# CITY OF ALBUQUERQUE

**Re: Campbell Brewery, 4814 Hardware Dr. NE**  
**Request for Certificate of Occupancy**  
**Transportation Development Final Inspection**  
Architect's Stamp dated 8-7-15 (F17D097)  
Certification dated 2-1-18

C1

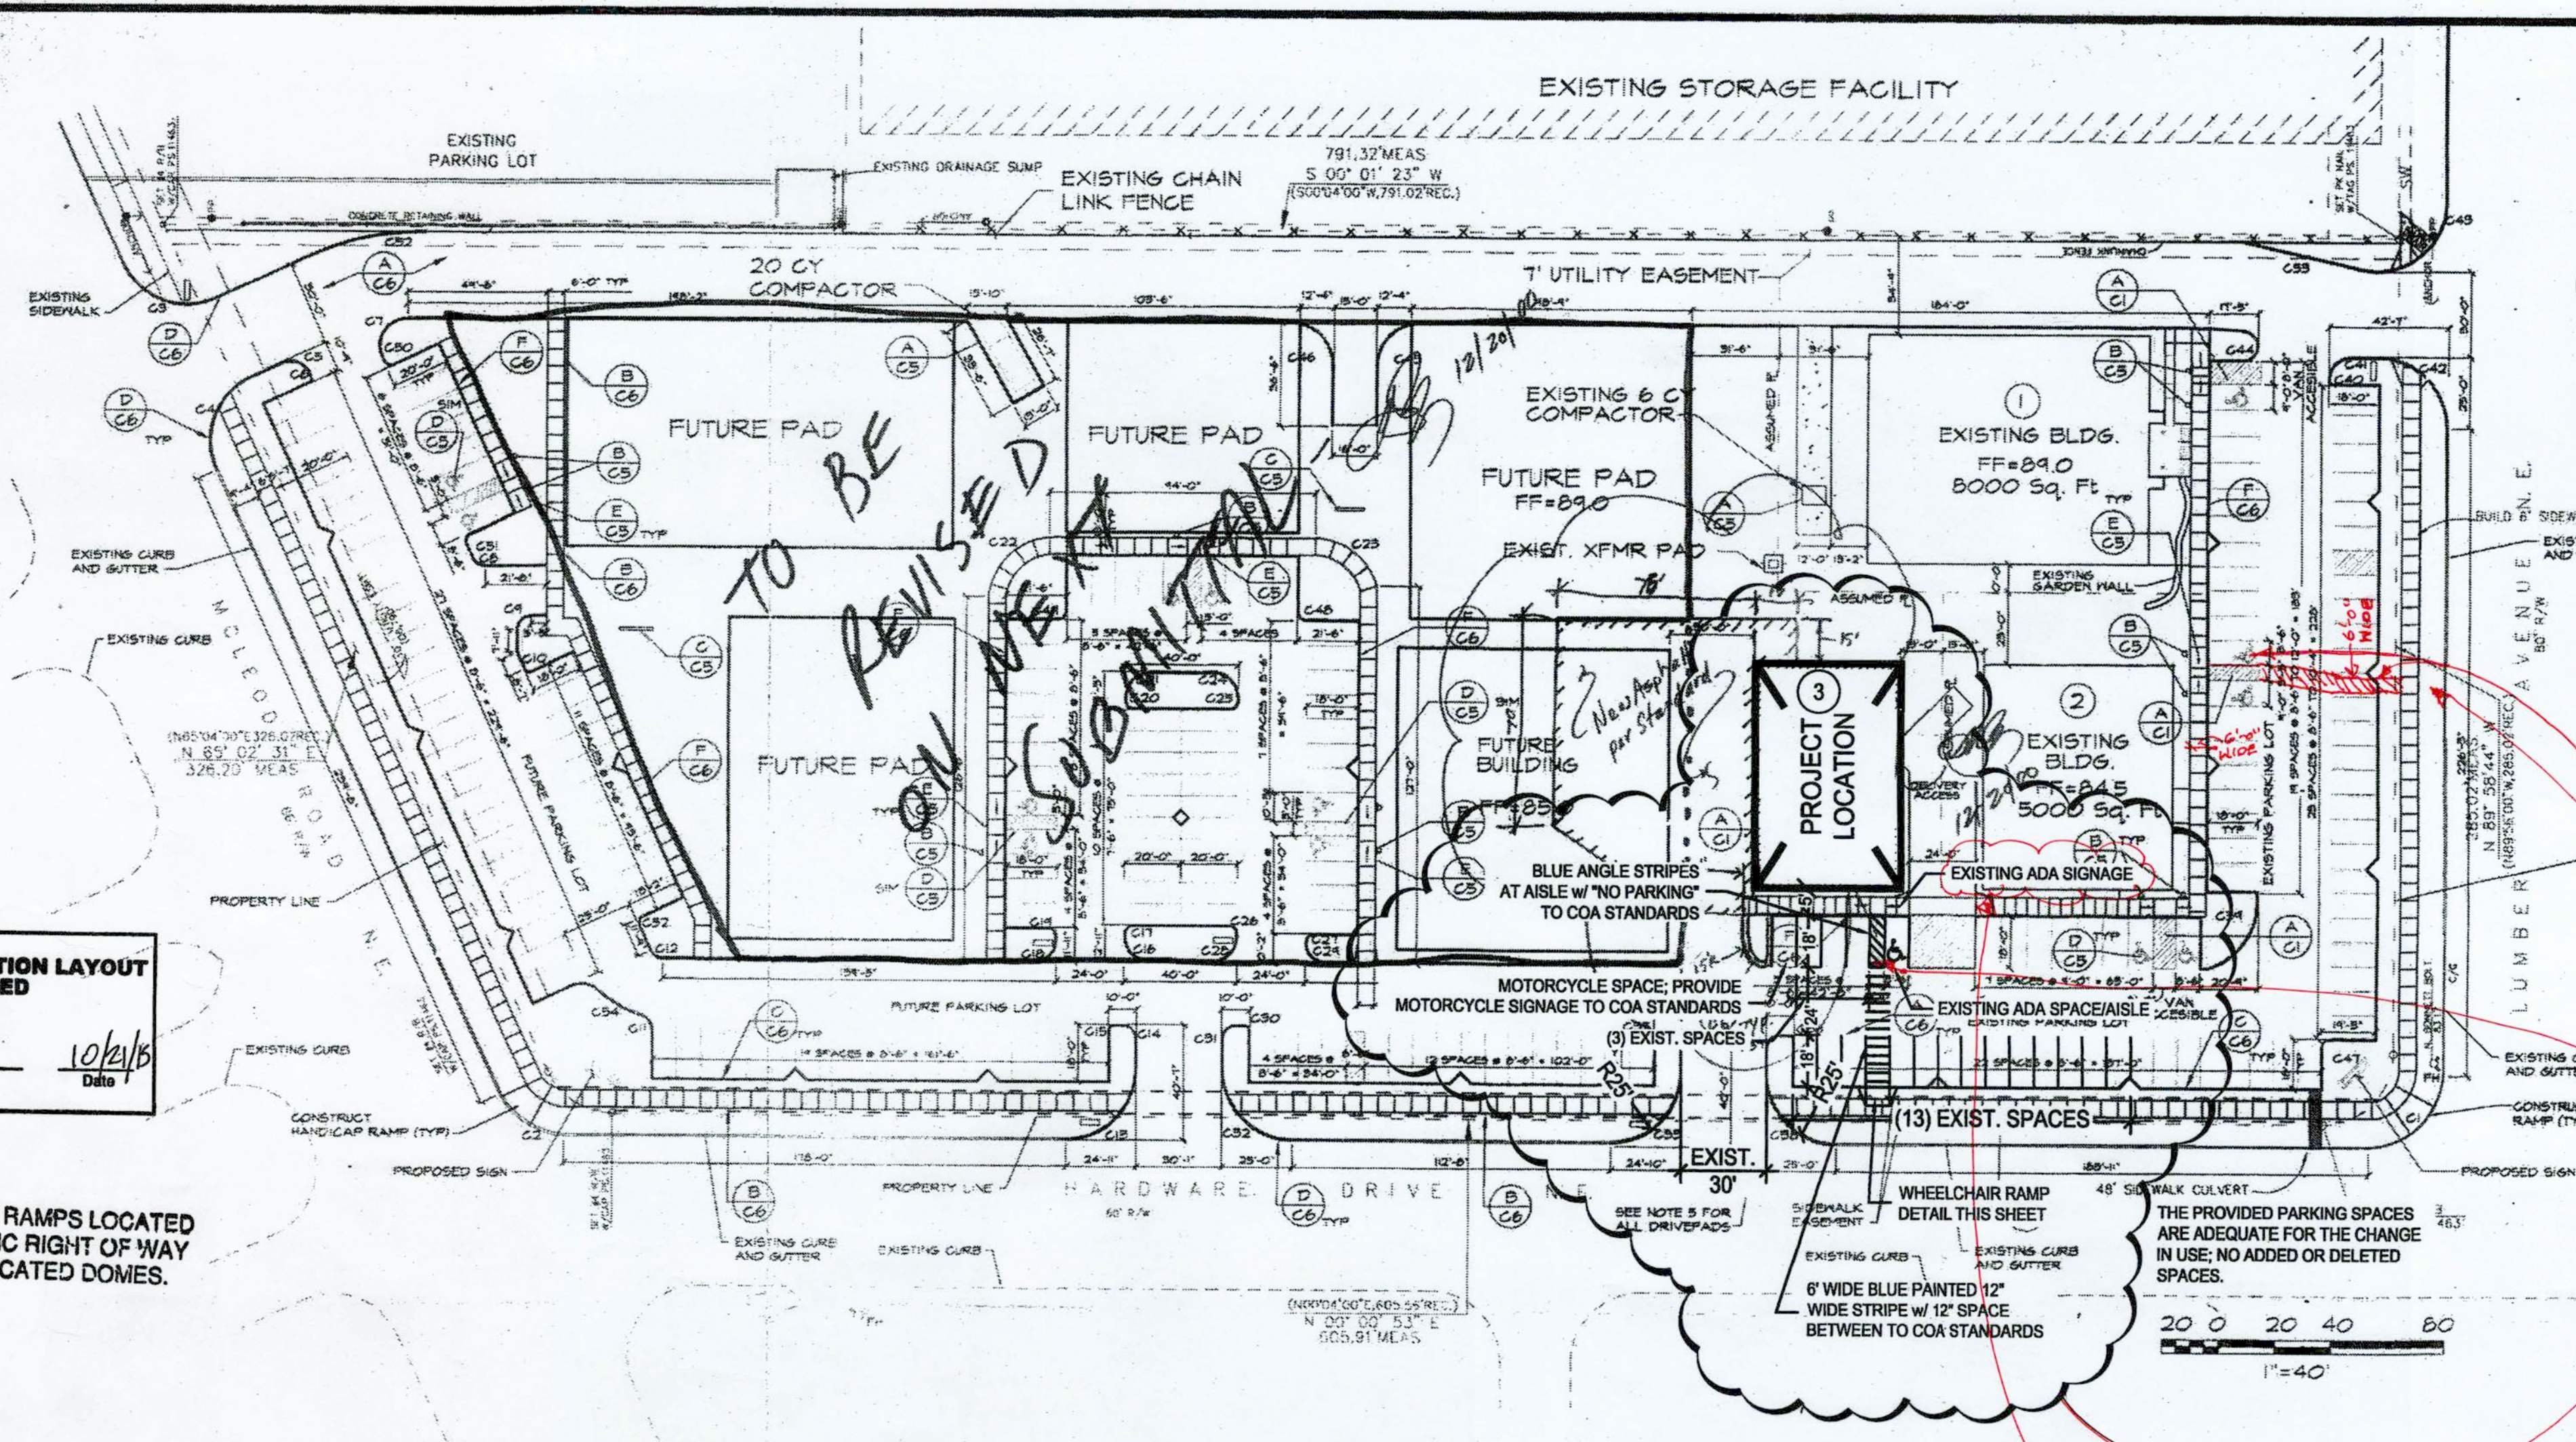
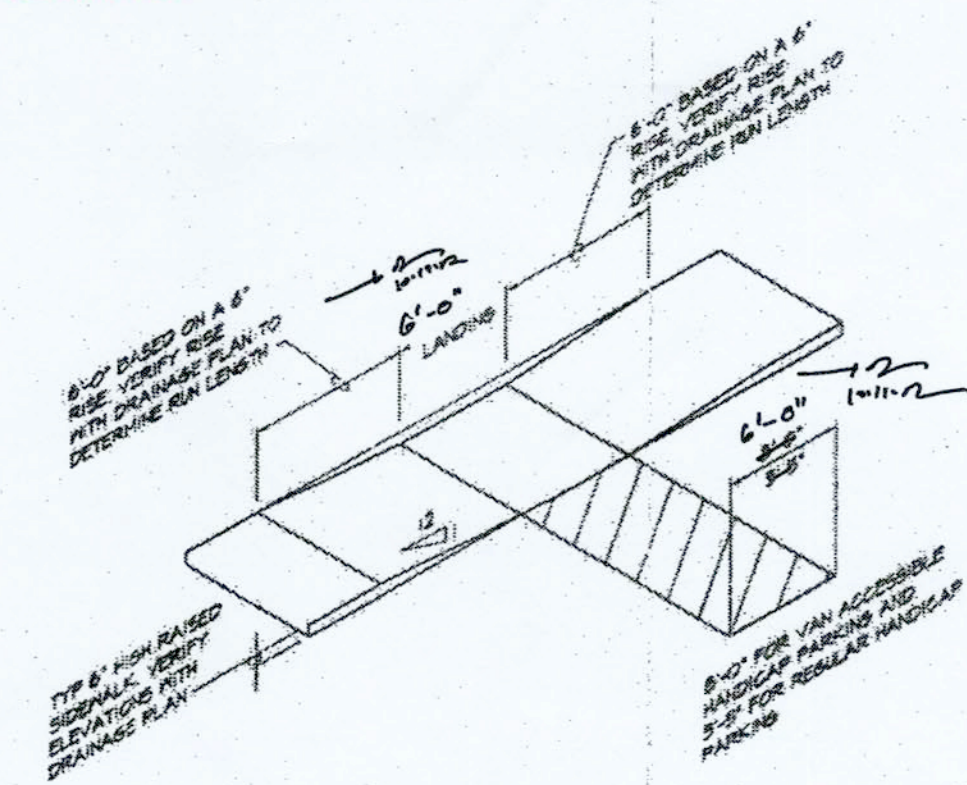
1. The ADA accessible parking sign must have the required language per 66-7-352.4C NMSA 1978 **"Violators Are Subject to a Fine and/or Towing."** Please call out detail and location of HC signs.
2. The ADA access aisles shall have the words **"NO PARKING"** in capital letters, each of which shall be at least one foot high and at least two inches wide, placed at the rear of the parking space so as to be close to where an adjacent vehicle's rear tire would be placed. (66-1-4.1.B NMSA 1978)
3. Per DPM, a 6 ft. wide ADA accessible pedestrian pathway is required from the HC parking stall access aisles to the building entrances. Please clearly show this pathway and provide details.
